SOUTH HOLLAND DISTRICT COUNCIL

To: Planning Committee - 07 June 2023

Purpose: To consider Planning Application H16-0042-23

Description: Change of use of a residential property (C3) to a HMO (C4 or Sui Generis) - re-submission of H16-0737-22

PARKING SURVEY
10th - 12th JANUARY 2023

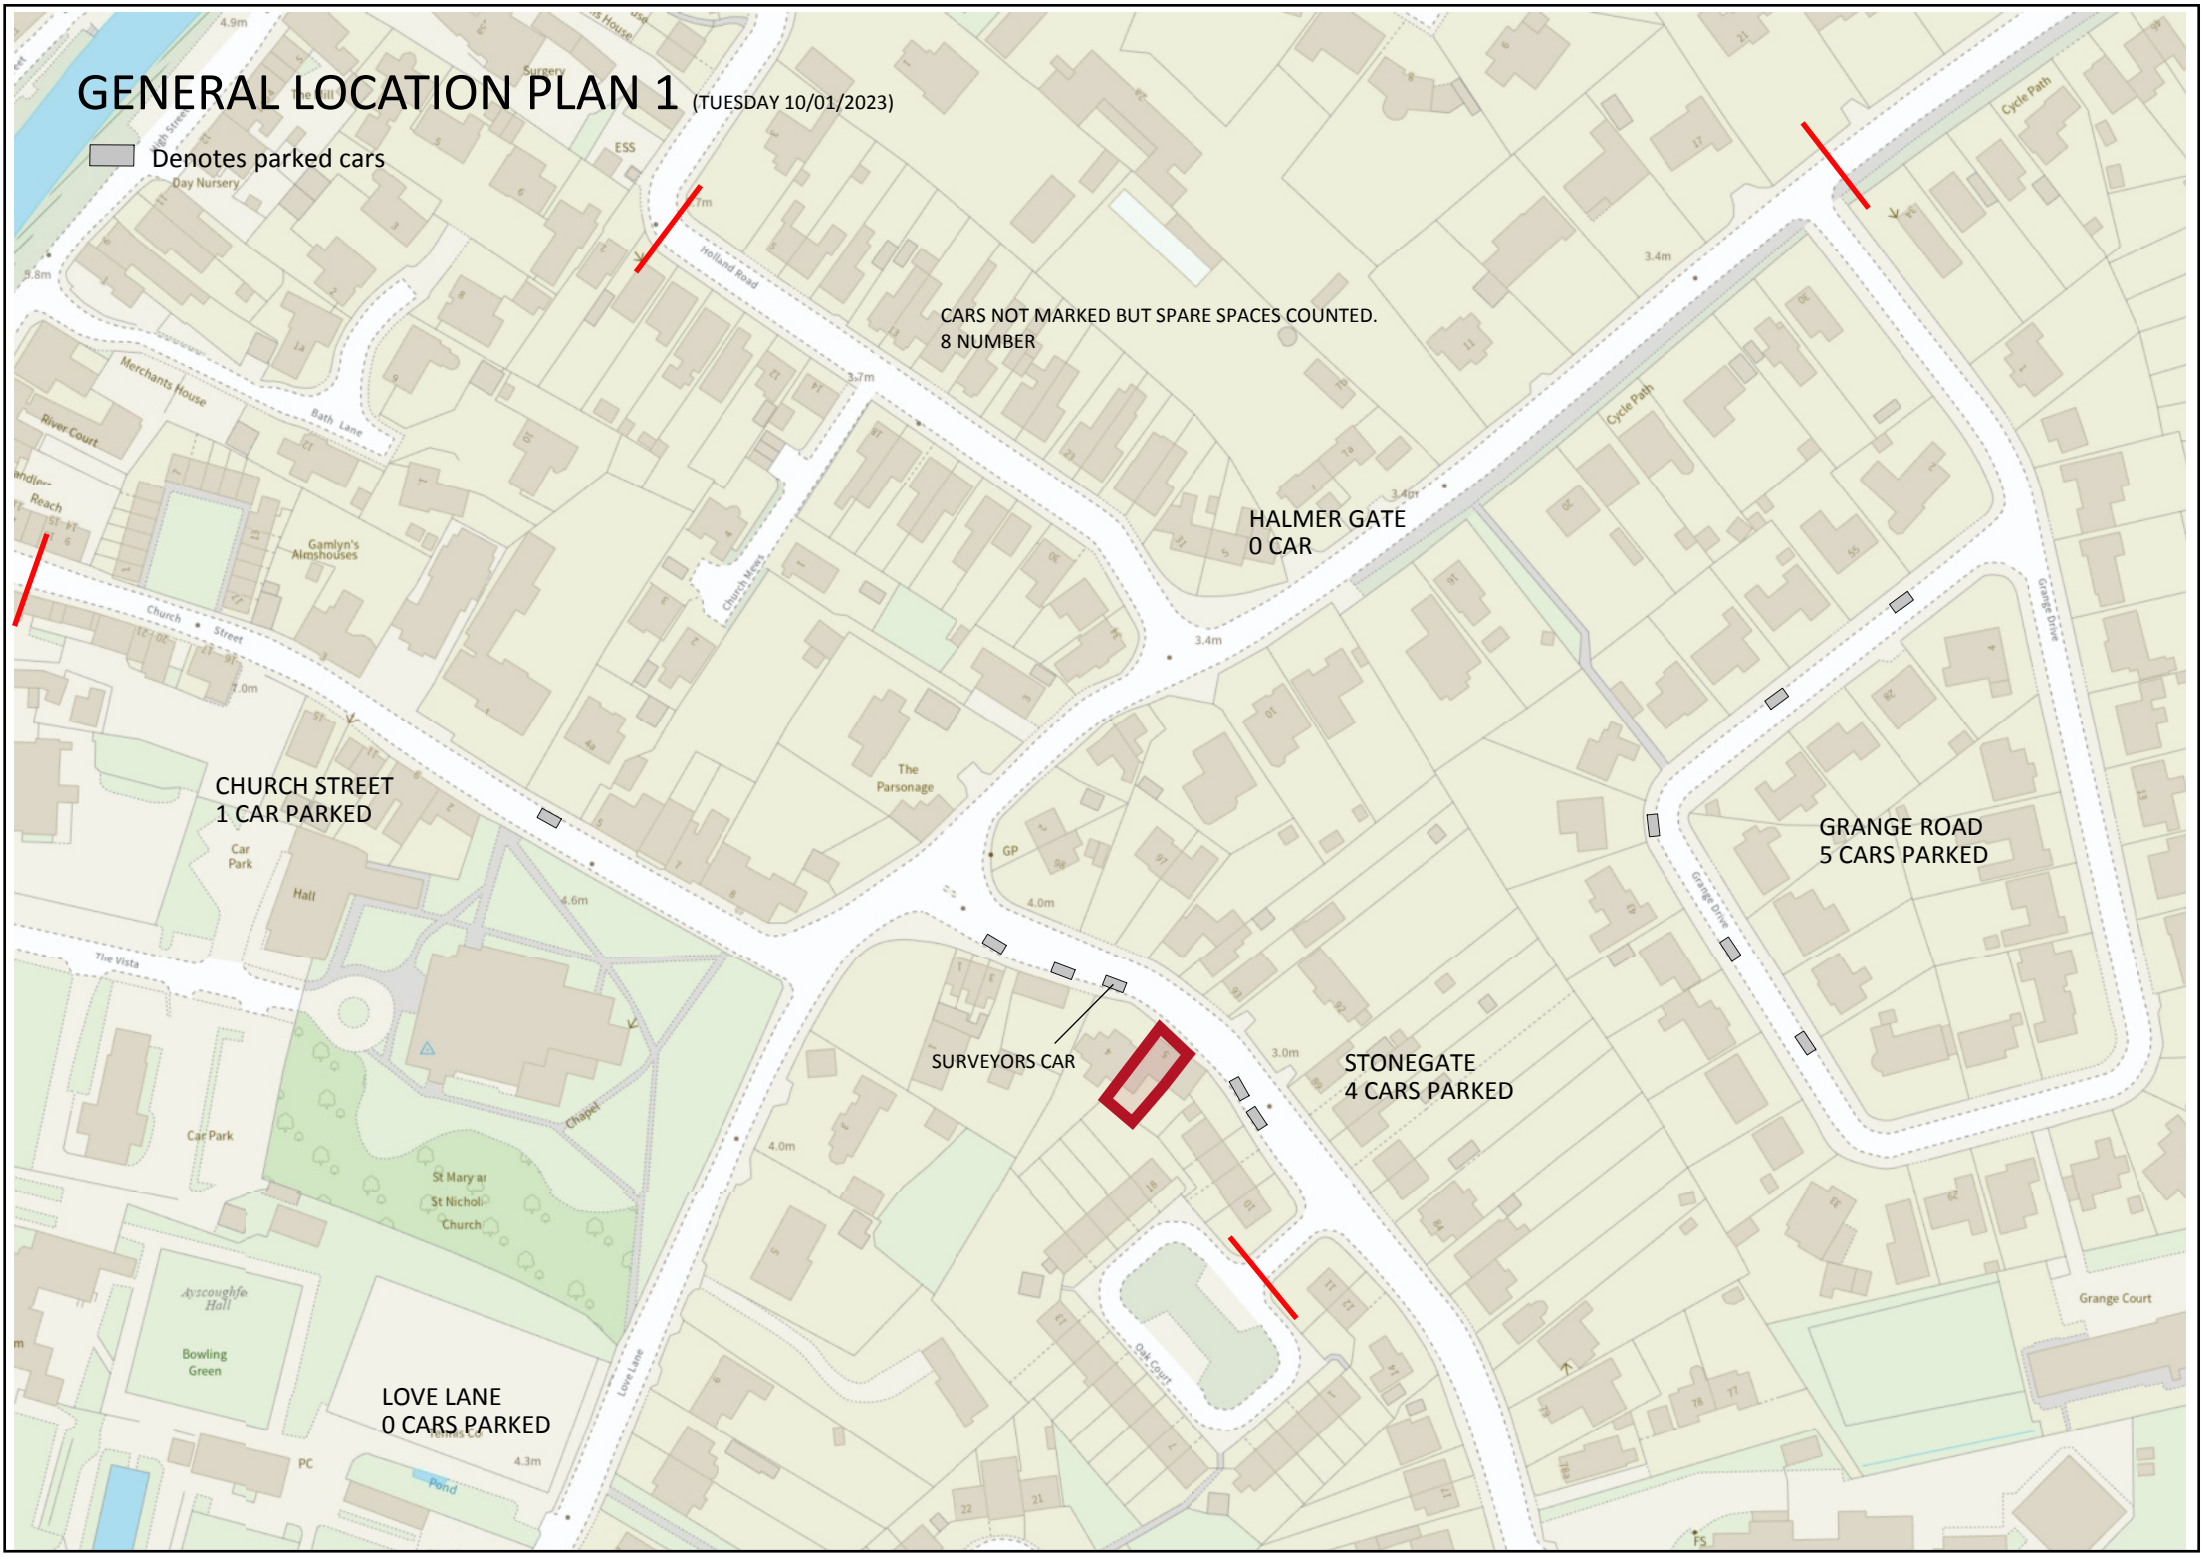
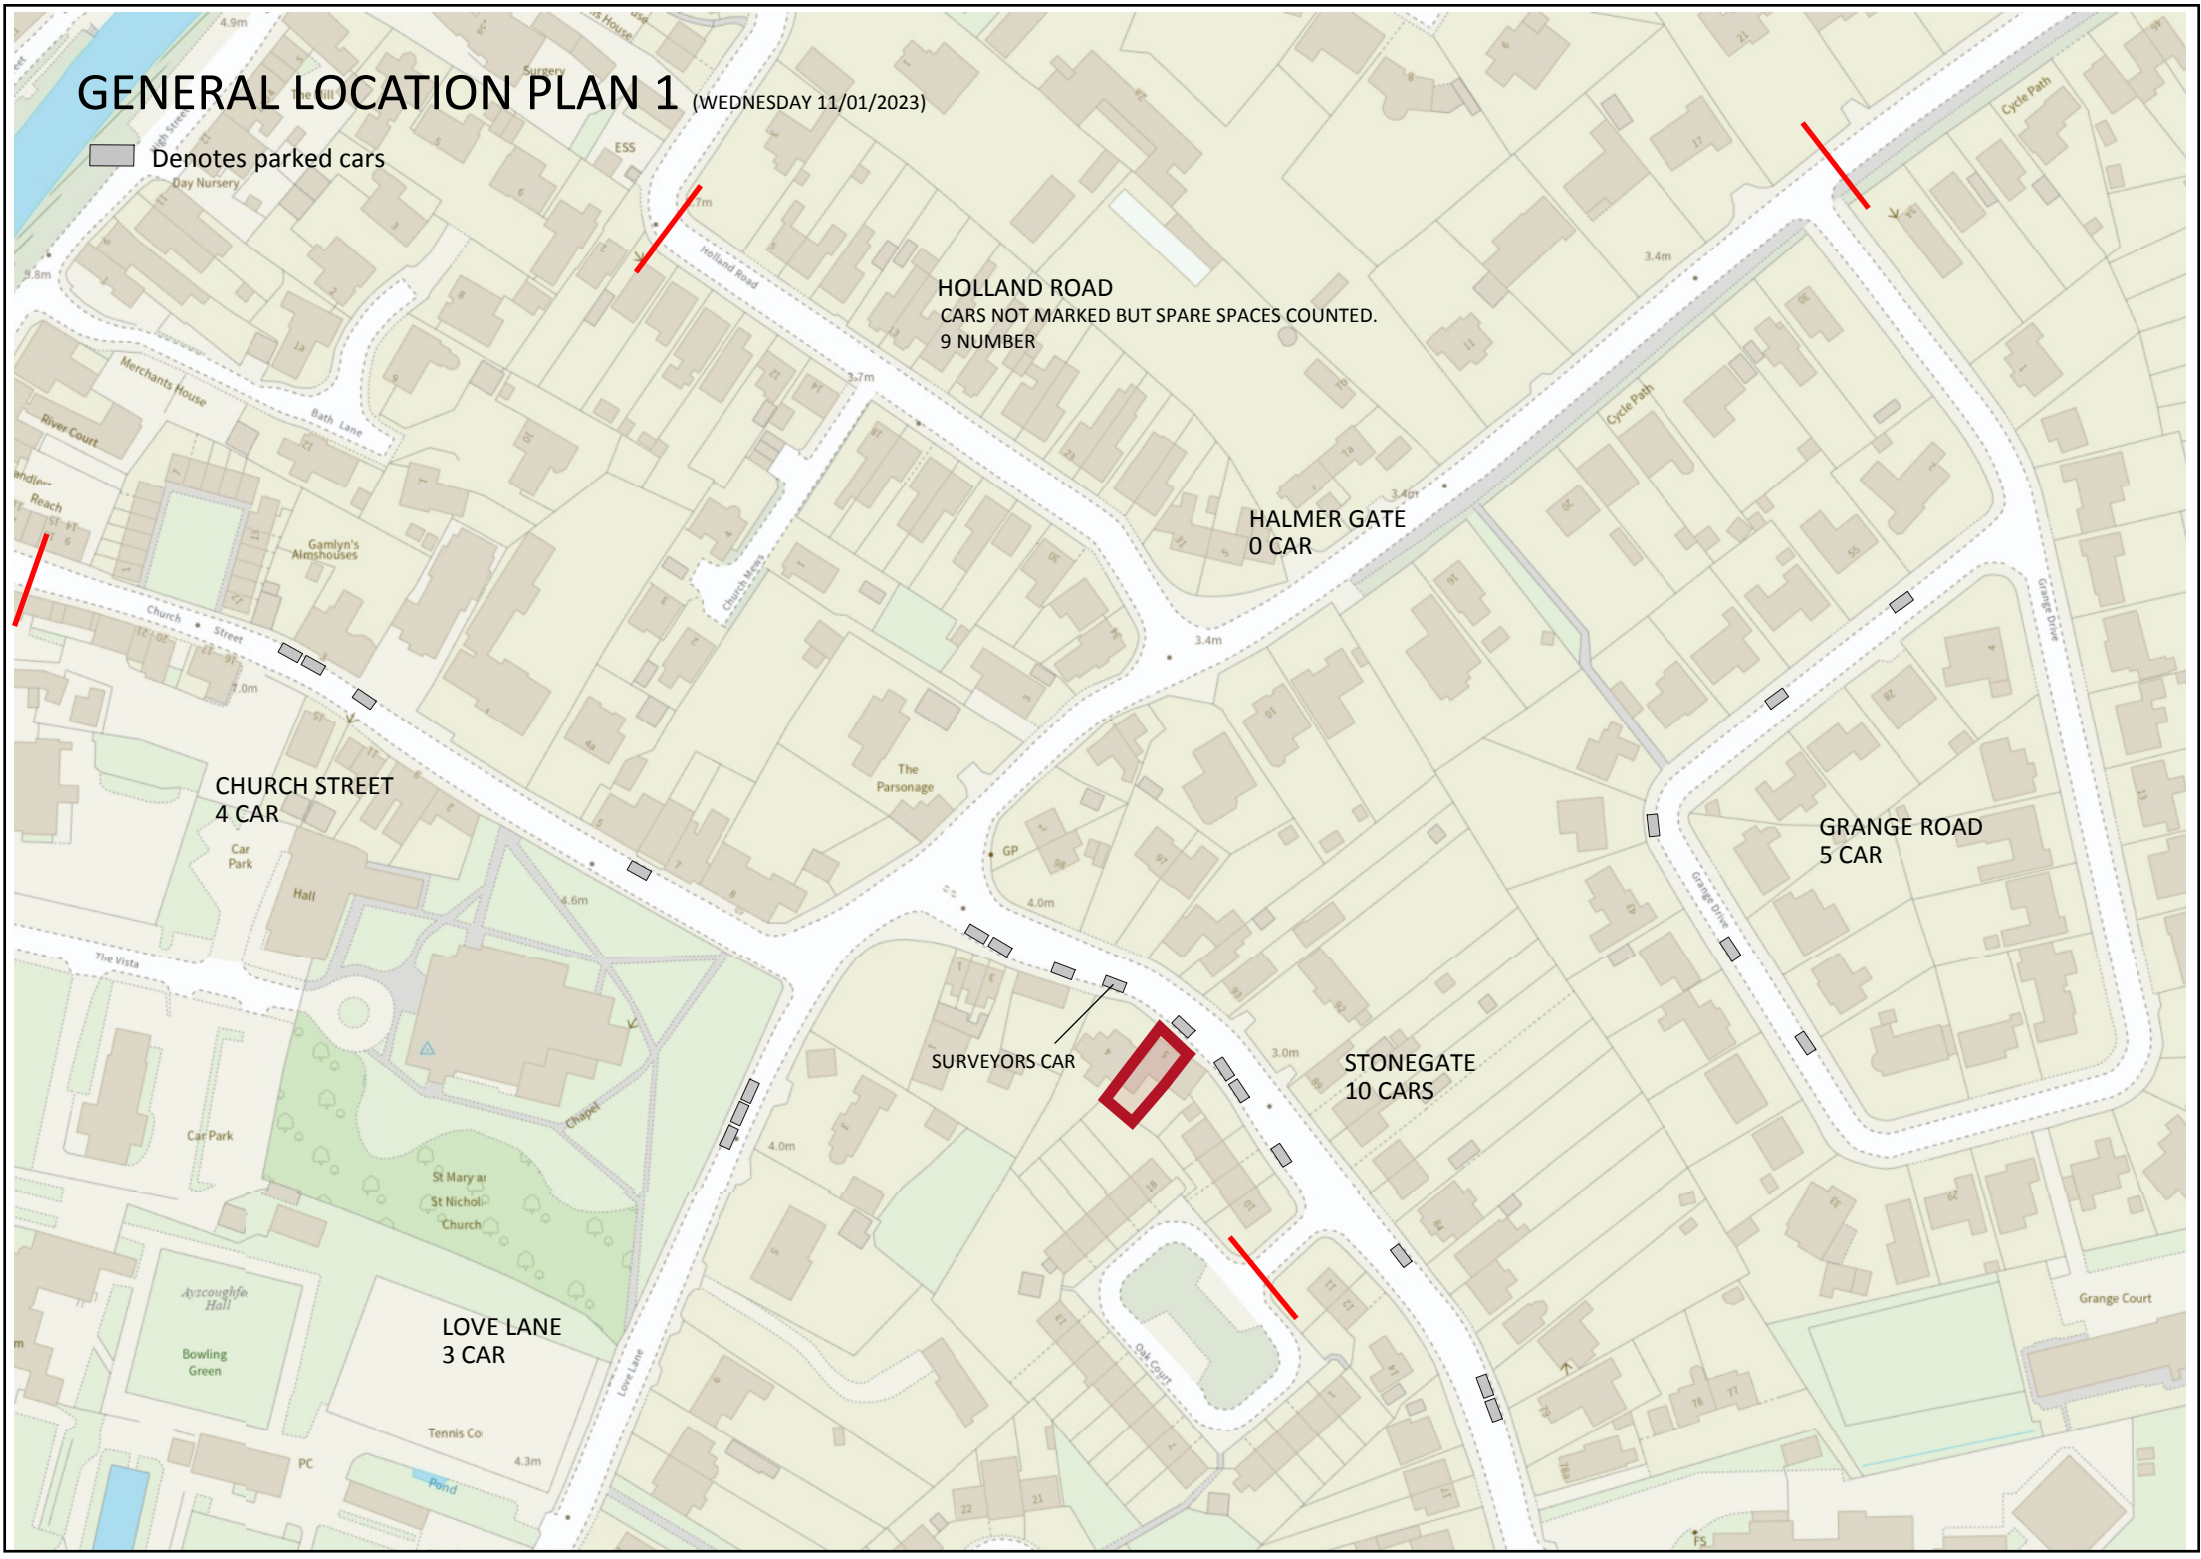
However, it is accepted that there is the possibility that not all future residents would have access to a private or personal vehicle or wish to have this access and the site, in its current form and lawful use, has the future potential for six occupants that each may have individual access to a vehicle. Furthermore, the Local Plan does not specify defined parking standards relating to HMOs. The submission has been accompanied by a parking survey, which was undertaken to illustrate the availability of parking spaces. This survey assessed the parking that was available within a 500m radius of the property, providing a suitable distance for walking to and from the property. The accompanying Design and Access Statement details that the survey

shows a total of 134 spaces being available within 500m of the site on the date of the survey, with in excess of 71 spaces available within a 300m radius of the site; therefore, indicating adequate parking availability within close proximity to the site.
